# Rezoning Transportation Analysis

Petition Number: #2022-048

**From: Jake Carpenter, PE**  
Jacob.Carpenter@charlottenc.gov  
980-221-5675

RZ-2

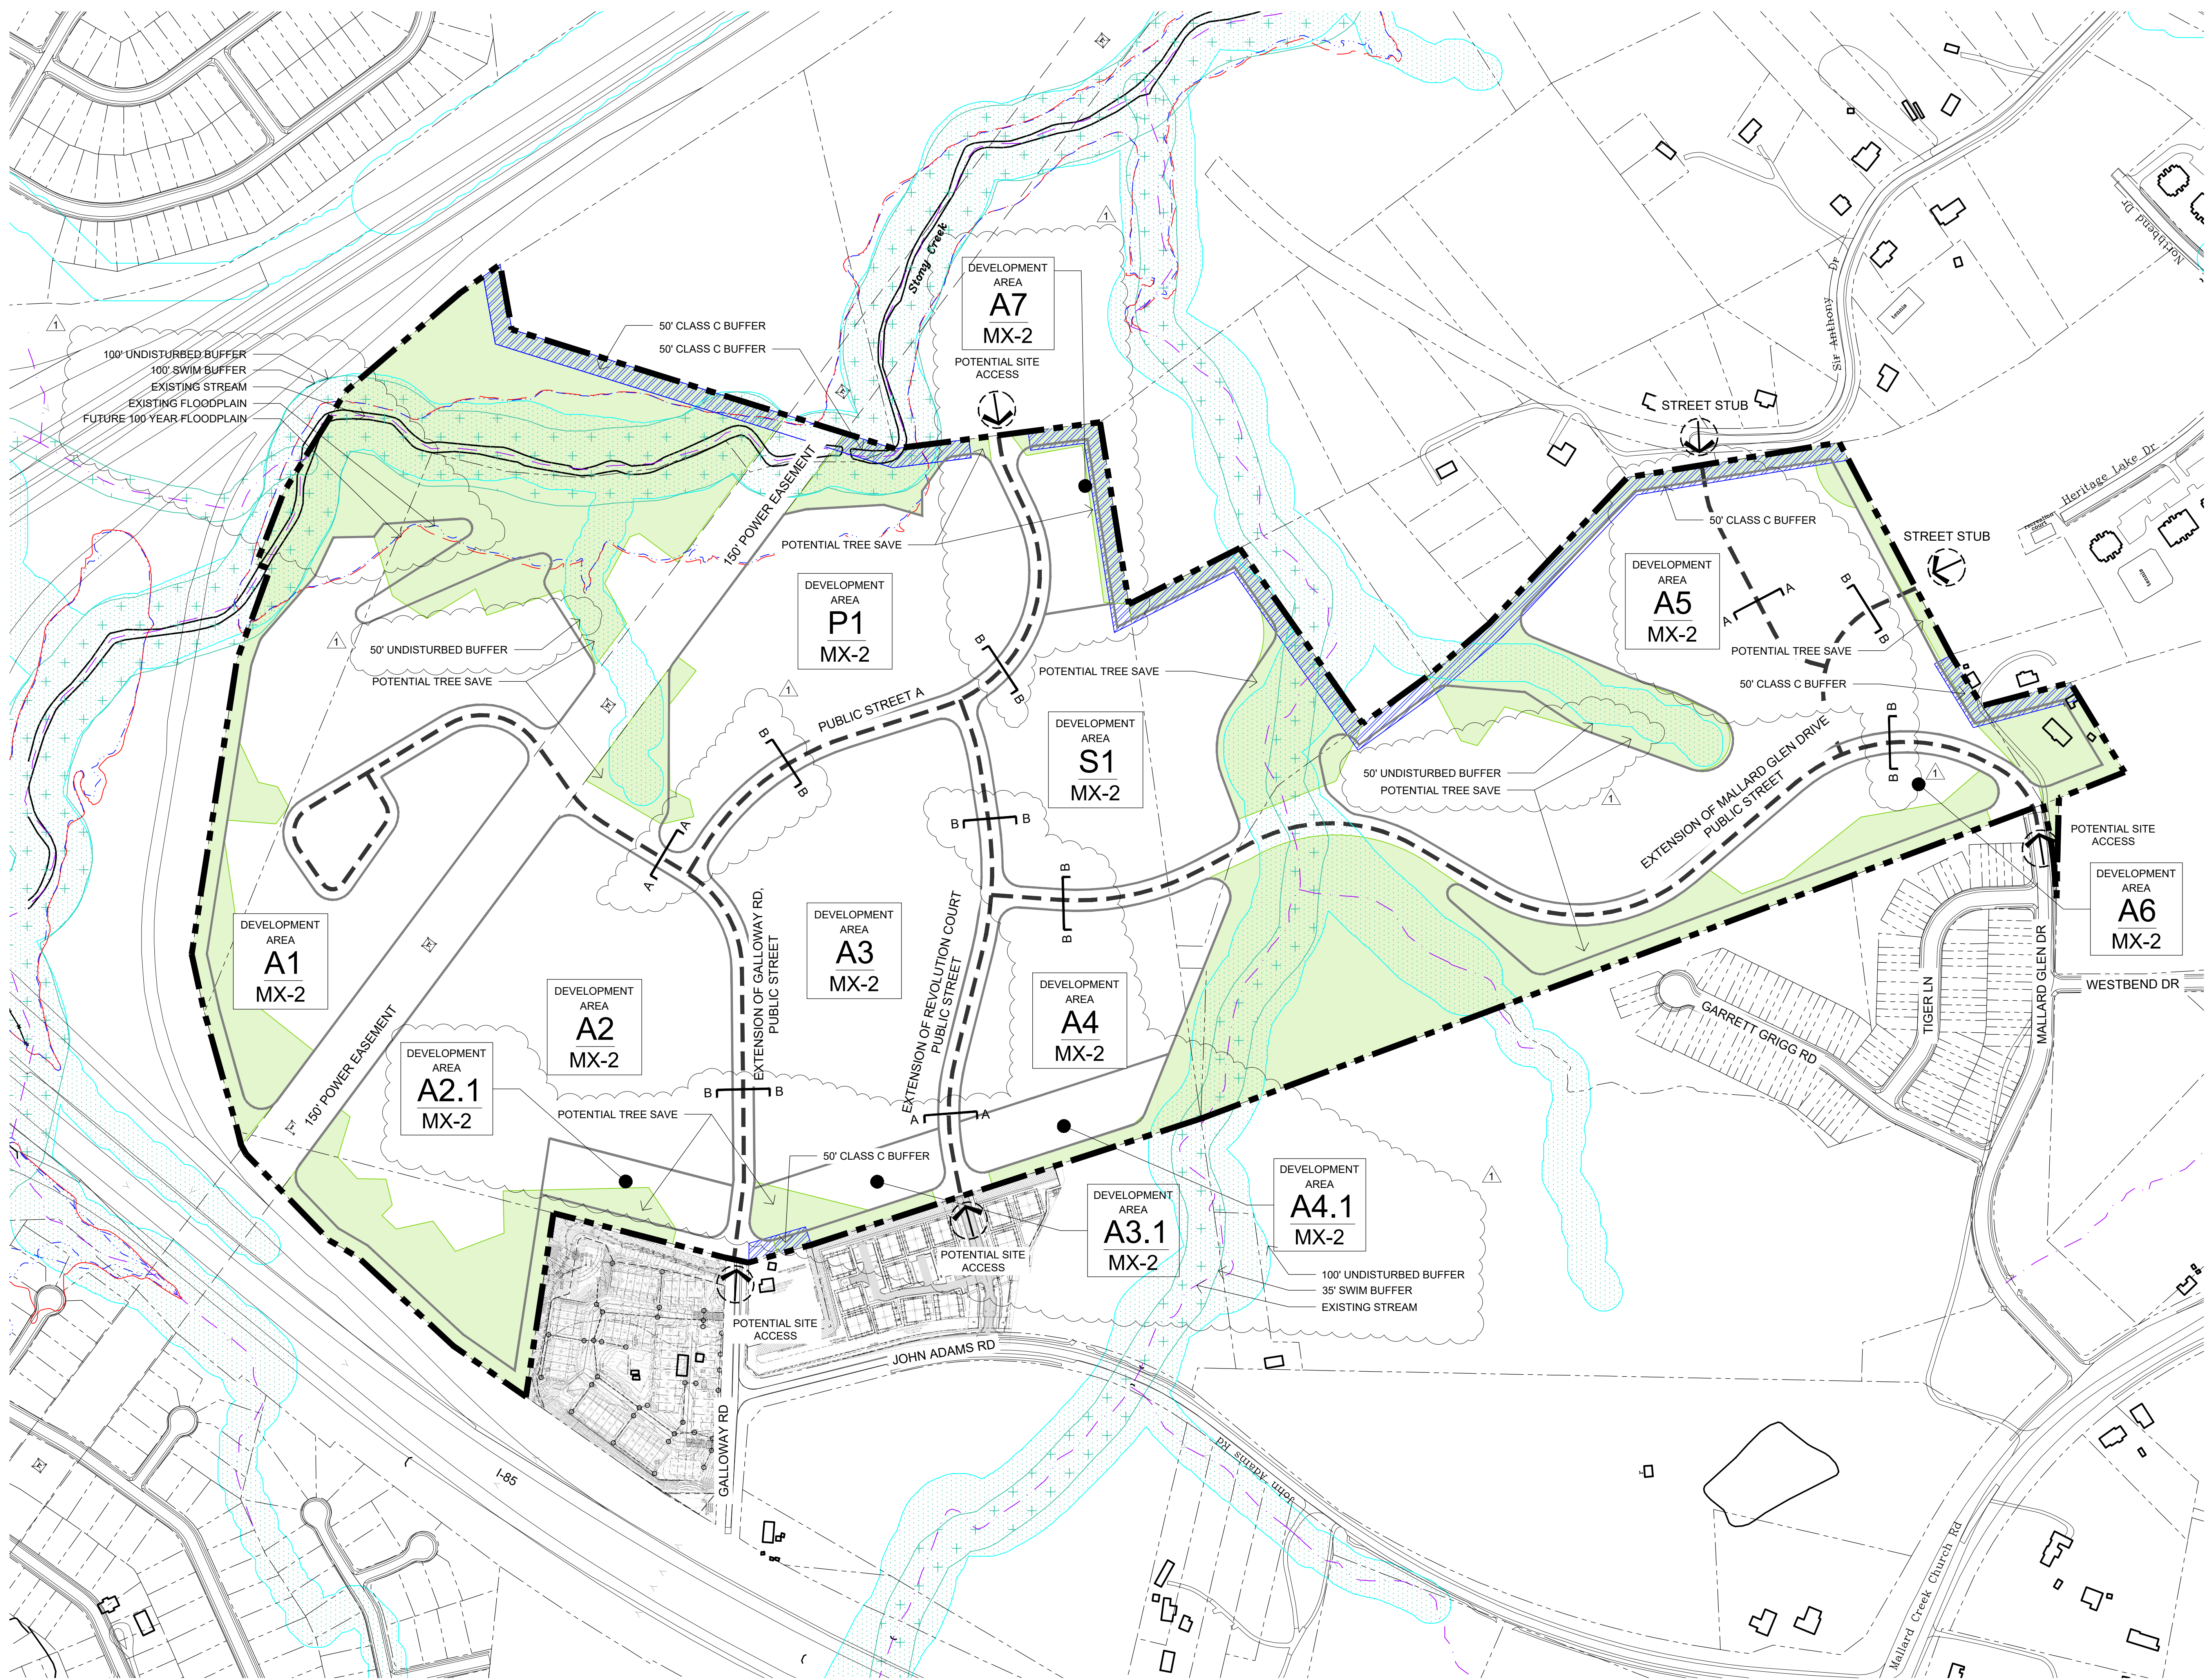
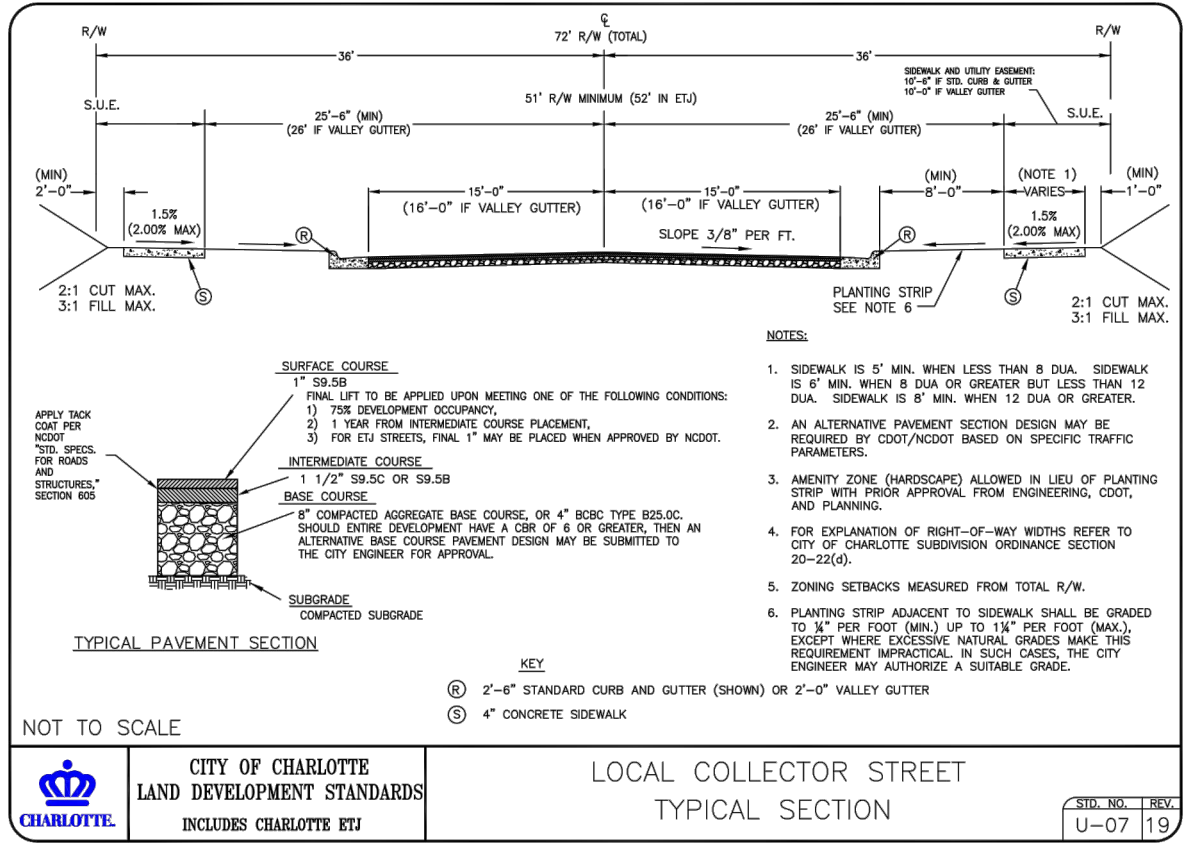
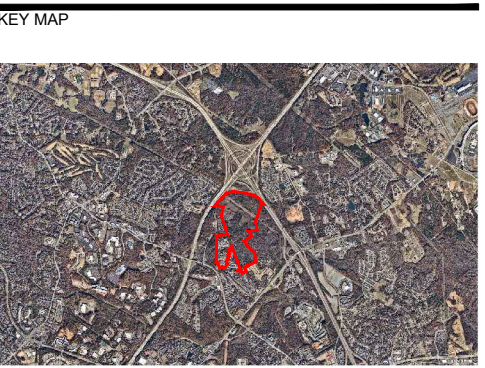
- ~~3. Outstanding Comment from 08-25-22: Revise site plan and conditional note(s) to commit to improving the existing Galloway Road stub to John Adams to the local collector street typical section per U-07.~~

- ~~4. Revise site plan and conditional note(s) to commit to the proposed roadway network typical sections and proposed phasing outlined in the Traffic Impact Study. Provide typical sections per CLDSM for all proposed public and private streets. Provide 8-foot sidewalk and 8-foot planting strip on all public streets.~~
